RE: Alternative Landscape Plan – PR-2018-001689

Upon review of your request letter and the corresponding alternative landscape plan, I have determined that this alternative landscape plan for the office/warehouse at 7200 Bluewater NW meets the criteria of Section 14-16-5-6(C)(16), and therefore is approved per the following findings:

Landscape Plan

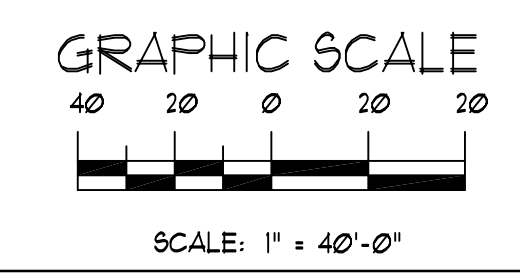
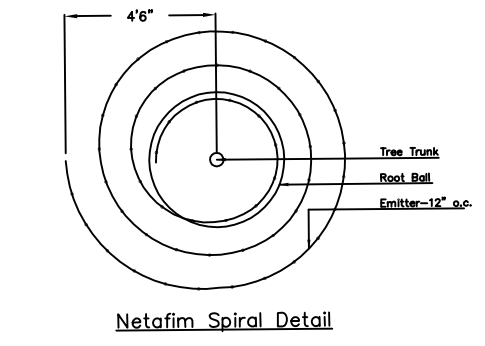
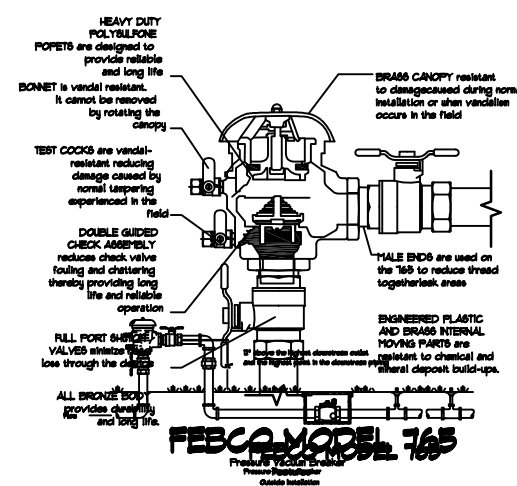
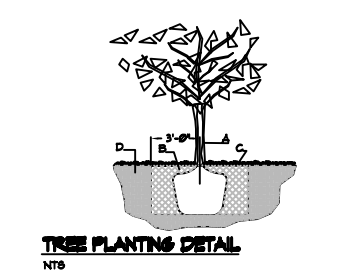
1. The applicant has submitted a Site Plan – DRB for a new office/warehouse building at 7200 Bluewater NW.
2. The proposed landscape plan meets all applicable Integrated Development Ordinance (IDO) development standards for landscape, except 14-16-5-6(C)(4)(h): “Shade trees planted approximately 25 feet on-center are required along all required pedestrian walkways.”

3. The submitted landscape plan has the required number of shade trees along the pedestrian walkway, but they are grouped in twos along the northern, front-side of the building.

4. The IDO Alternative Landscape Plan criteria of Section 14-16-5-6(C)(16) are met as follows:
 - a. The alternative landscape plan is consistent with purpose of Section 14-16-5-6 because: the required number of trees will be provided; the alternative approach provides a quality visual component and other public benefits including the use of native and low-water use species, improved air quality, and providing shade to mitigate heat-island effects with grouped trees along the north side of the building.

- b. The proposed landscaping will not include vegetation that is prohibited or invasive or listed as noxious weeds.
 - c. There will be no reduction of tree planting requirements. The required numbers of trees are distributed where required and in other locations that will benefit the site.

- d. The alternative landscape plan does not affect perimeter buffer or landscape areas.
 - e. The alternative landscape plan provides equal visual appearance of the property when viewed from Bluewater Road NW.
 - f. The design will provide equal levels of carbon dioxide absorption and heat island reductions.
5. Development of this infill site with the provision of the required number trees is consistent with the ABC Comp Plan Vision for desired growth in or near existing and designated Centers (West Route 66) and Corridors (Major Transit Corridor and Main Street).
